Planning Application Reference: 6/2017/1079/FULL
Proposed development at: 37 Lambs Close, Cuffley, Potters
Bar, Hertfordshire EN6 4HD
The erection of x3 two-bedroom flats and provision of x3 car parking
spaces

I am writing to object to planning application 6/2017/1079/FULL on the ground of insufficient off-street car parking spaces.

5 Proposed Site Plan - Roof Plan
1:200

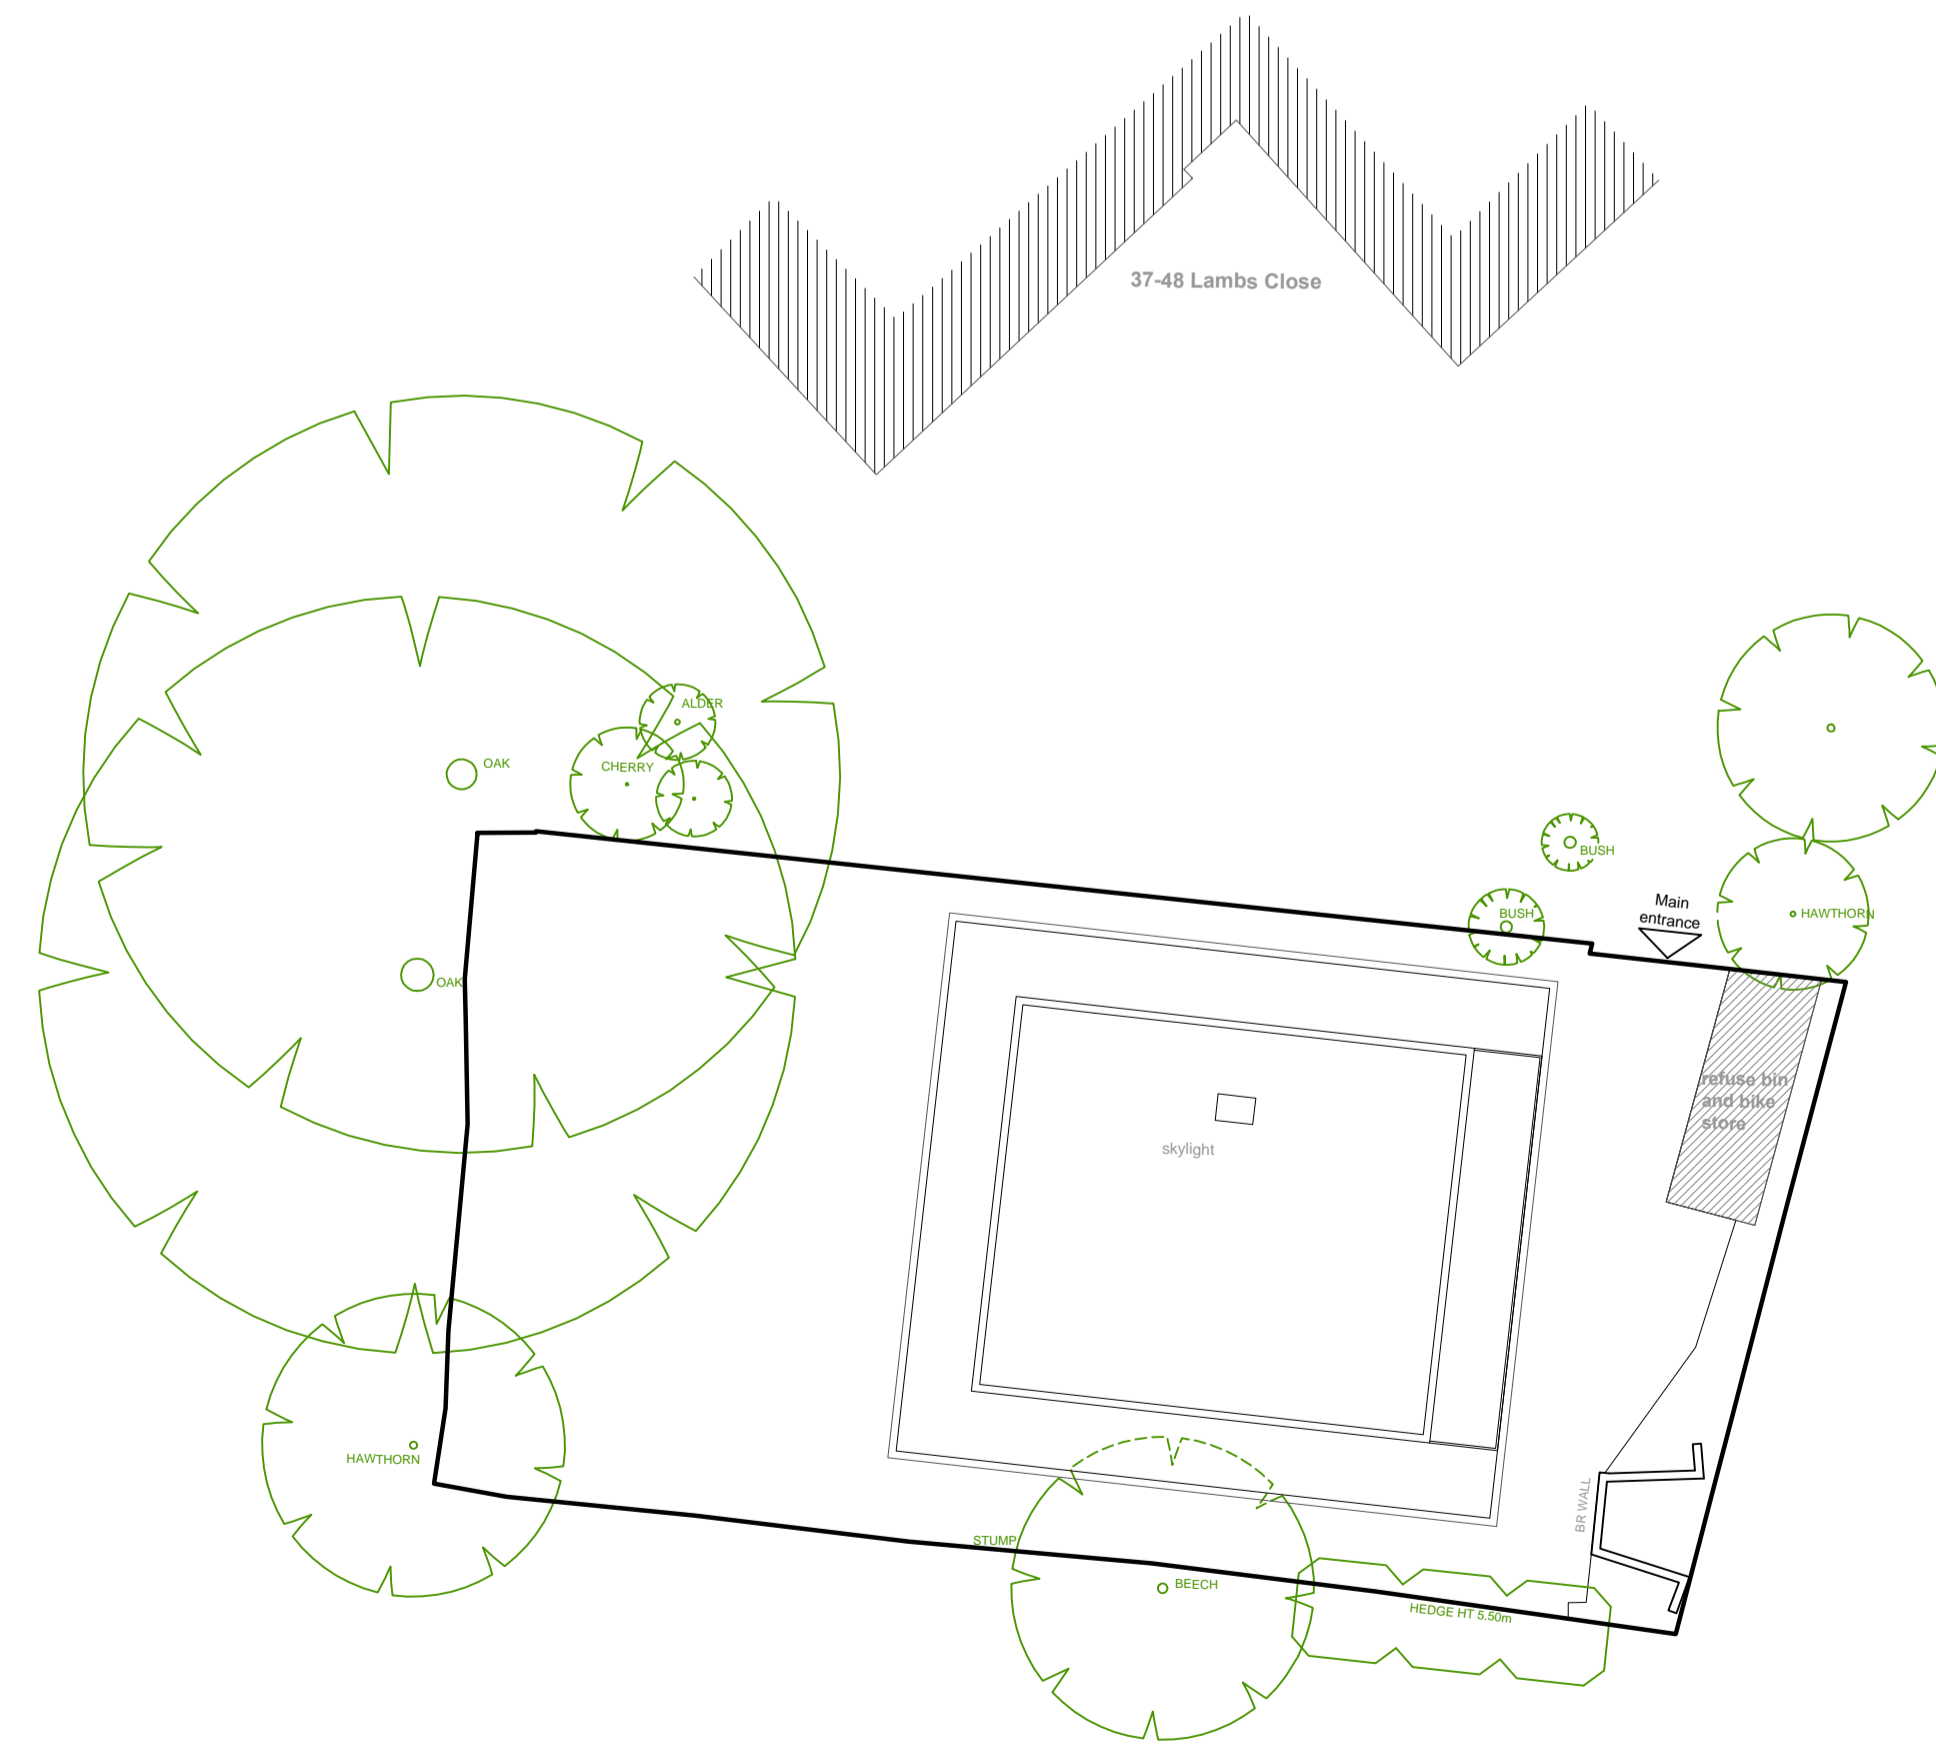
There are already not enough off-street or on-street car parking spaces for residents of the existing four blocks of flats. Planning application 6/2017/1079/FULL proposes only one off-street car parking space per two bedroom flat. This will inevitably cause overspill car parking along Lambs Close, exacerbating the aforementioned car parking problem.
